# HyNet North West

## APPLICANT'S COMMENTS ON SUBMISSIONS RECEIVED AT DEADLINE 3

HyNet Carbon Dioxide Pipeline DCO

**Document Reference Number D.7.21**

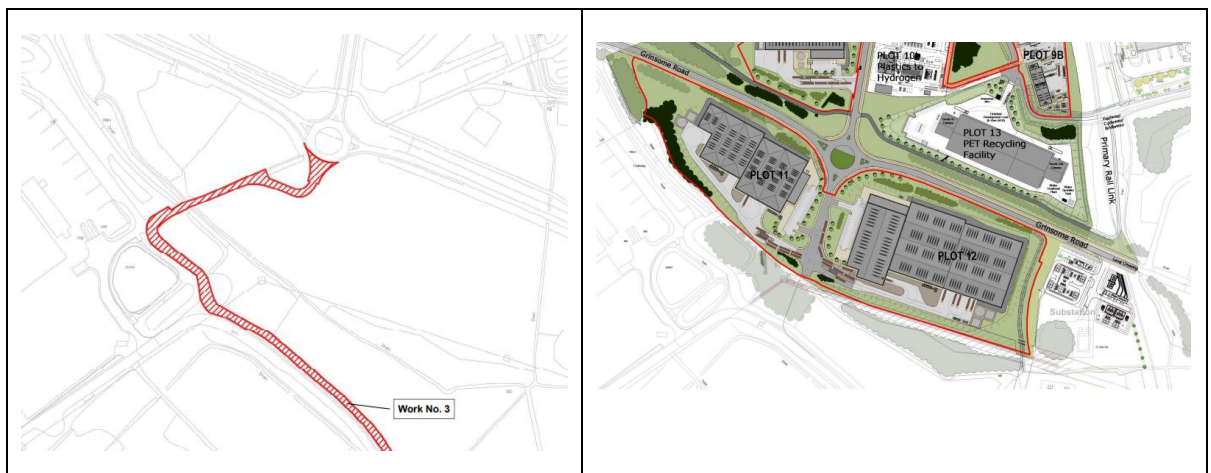
2.1.21	2.21	The updates provided by the Applicant do not address the objections previously raised by Peel NRE and continues to conflict with the delivery of the approved Protos Plastics Park (CWACC Planning application ref. 21/04076/FUL), and the delivery of the railway 6 line consented as part of the overarching planning permission for Protos (ref. 14/02277/S73), which would constrain the delivery of the developments. Therefore, at this stage, Peel NRE objects to the proposed access (as shown on Works Plan ref. EN070007-D.2.4-WP-Sheet 1).	The Applicant acknowledges Peel NRE's response and will continue to engage with them through the Draft SoCG [REP3-027].

2.1.22	2.22	A plan of the approved Plastics Park masterplan (ref. 20039-FRA-XX-00-DR-A-90-0005 P2) is provided with an overlay of the proposed access route to the Ince AGI and pipeline (shown on plan ref. EN070007-D.2.4-WP-Sheet 1). This is provided at Figure 1 (and at Appendix 16 to the Written Representations (17 April 2023)). This overlay plan clearly shows the conflict of the Applicant's proposed access with the planned development of the Plastics Park at Protos.

Figure 2.1 - CO₂ Pipeline within the wider Project

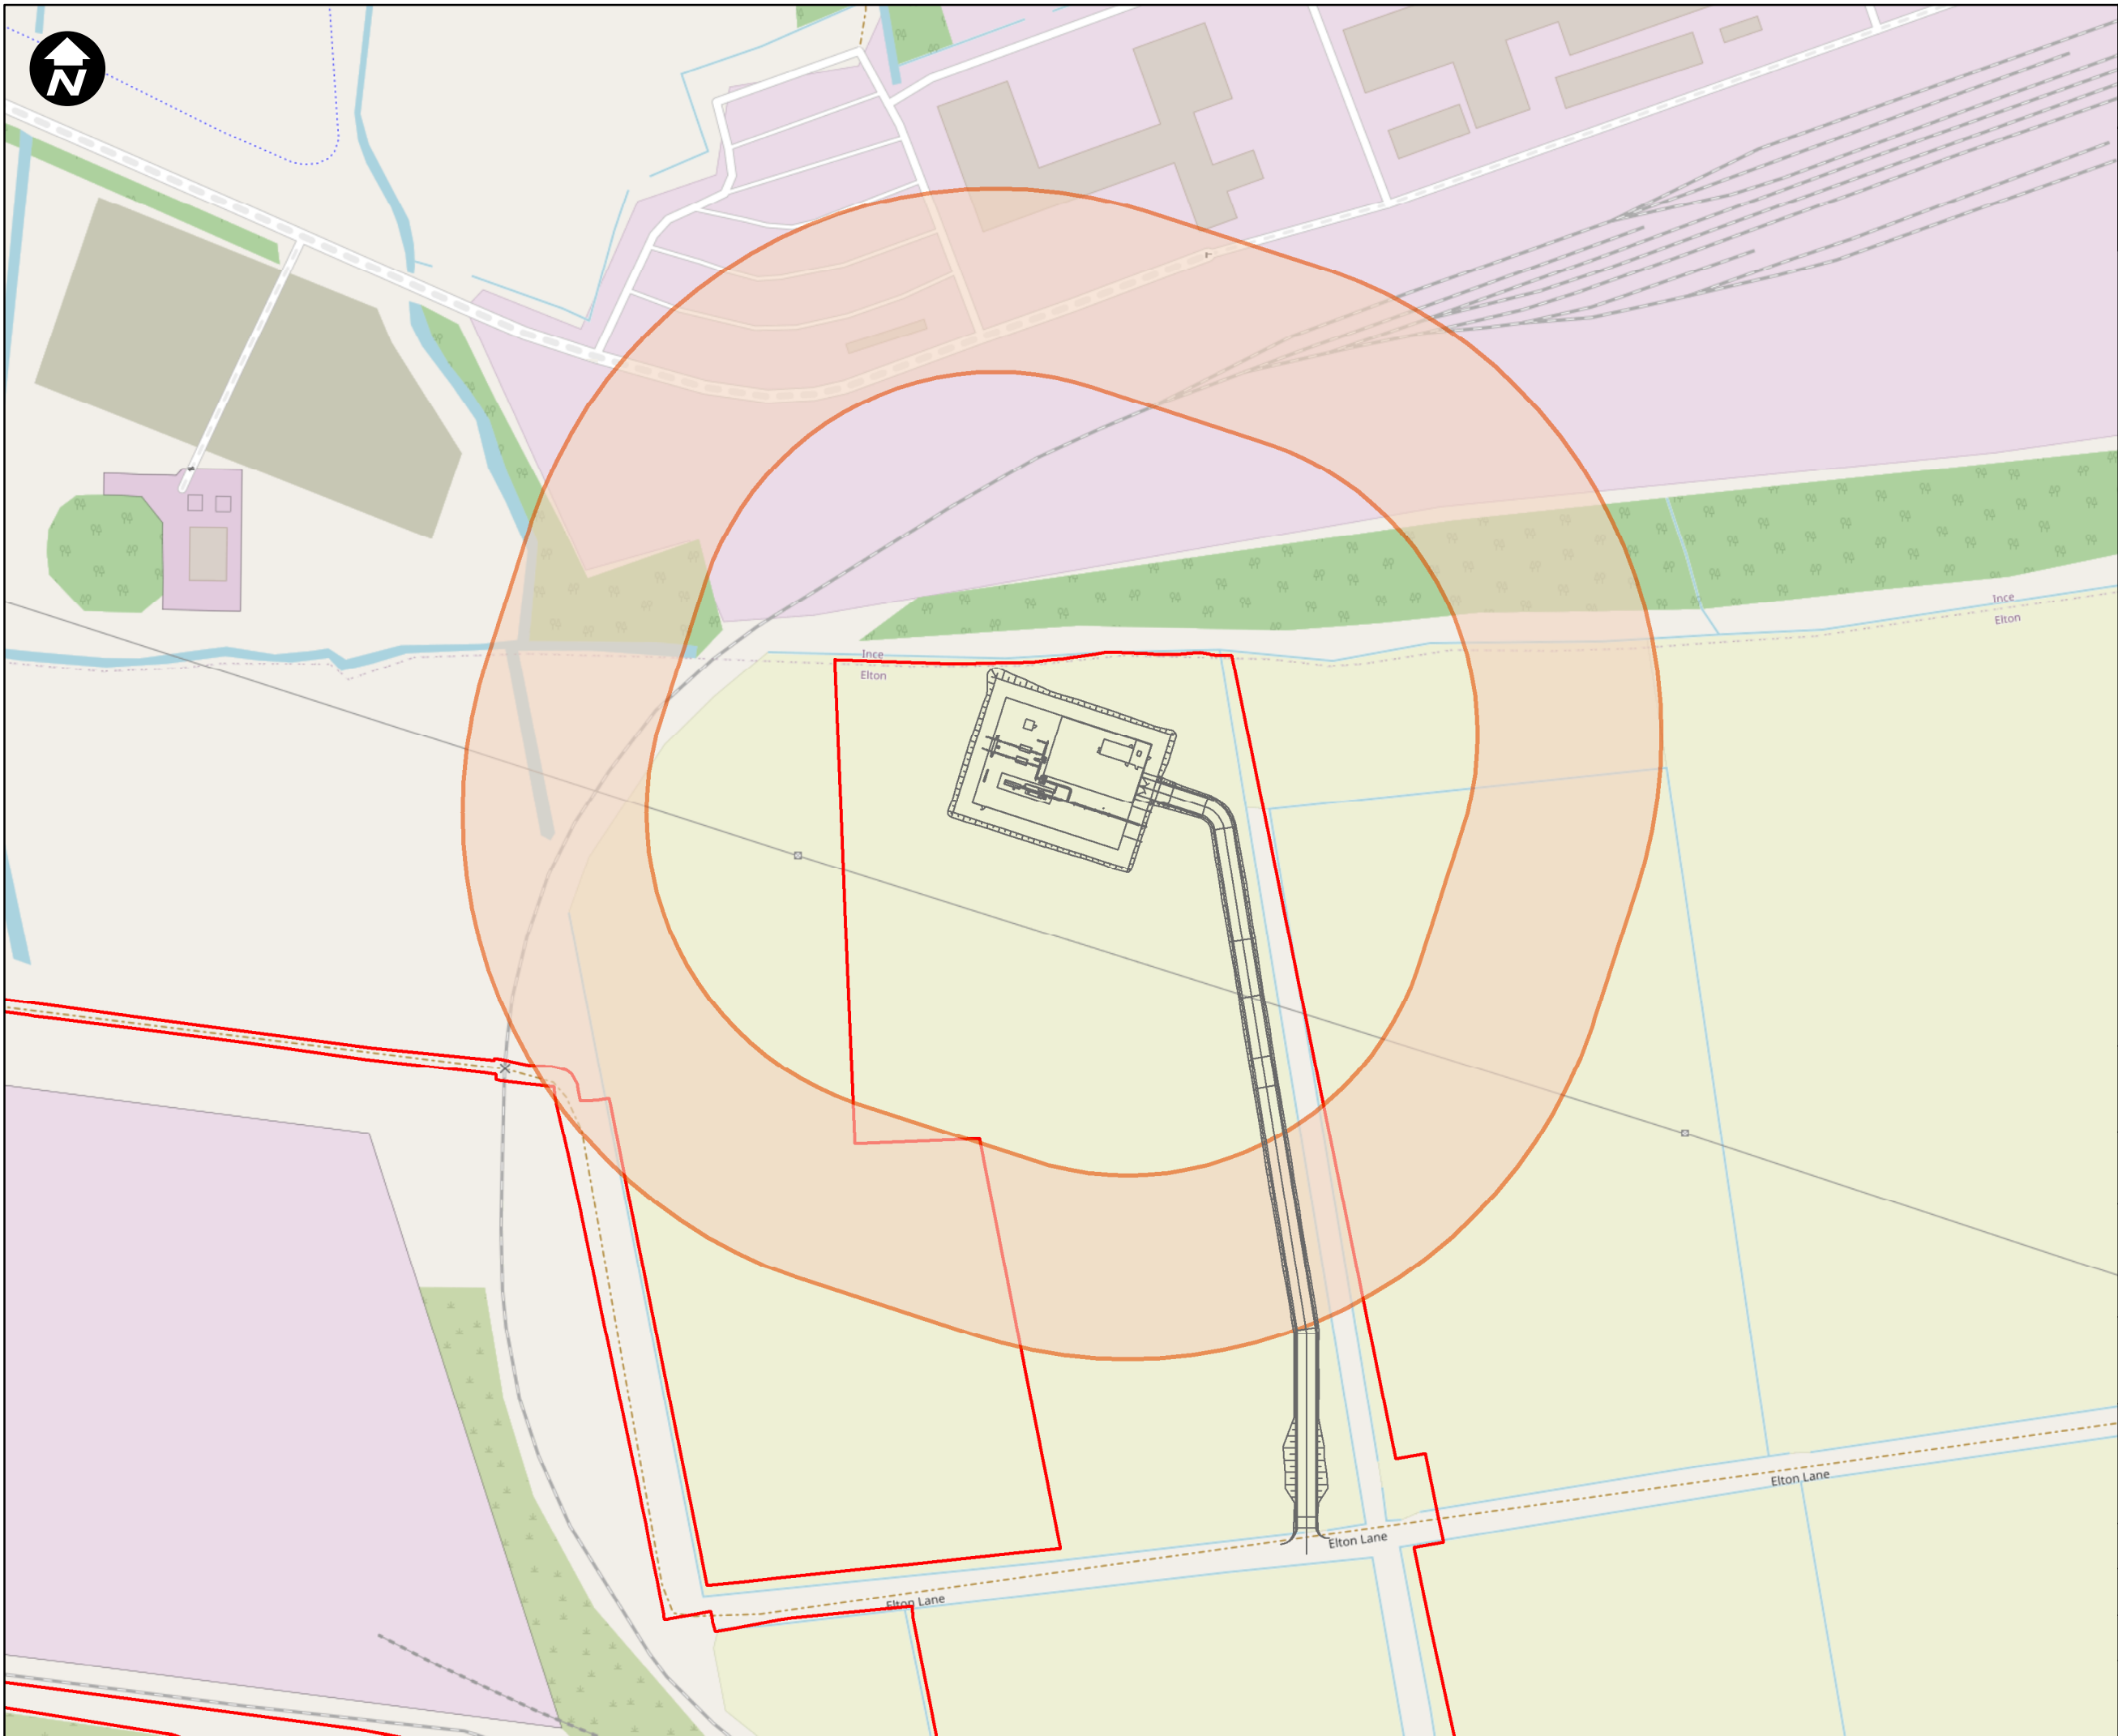
2.1.27	2.27	The Applicant has identified the potential for odour emissions at the Ince AGI, with associated Odour Zone, which lies close to Protos (shown on Figure 6.3, Rev B).	The Applicant acknowledges Peel NRE's response and has no further comments.
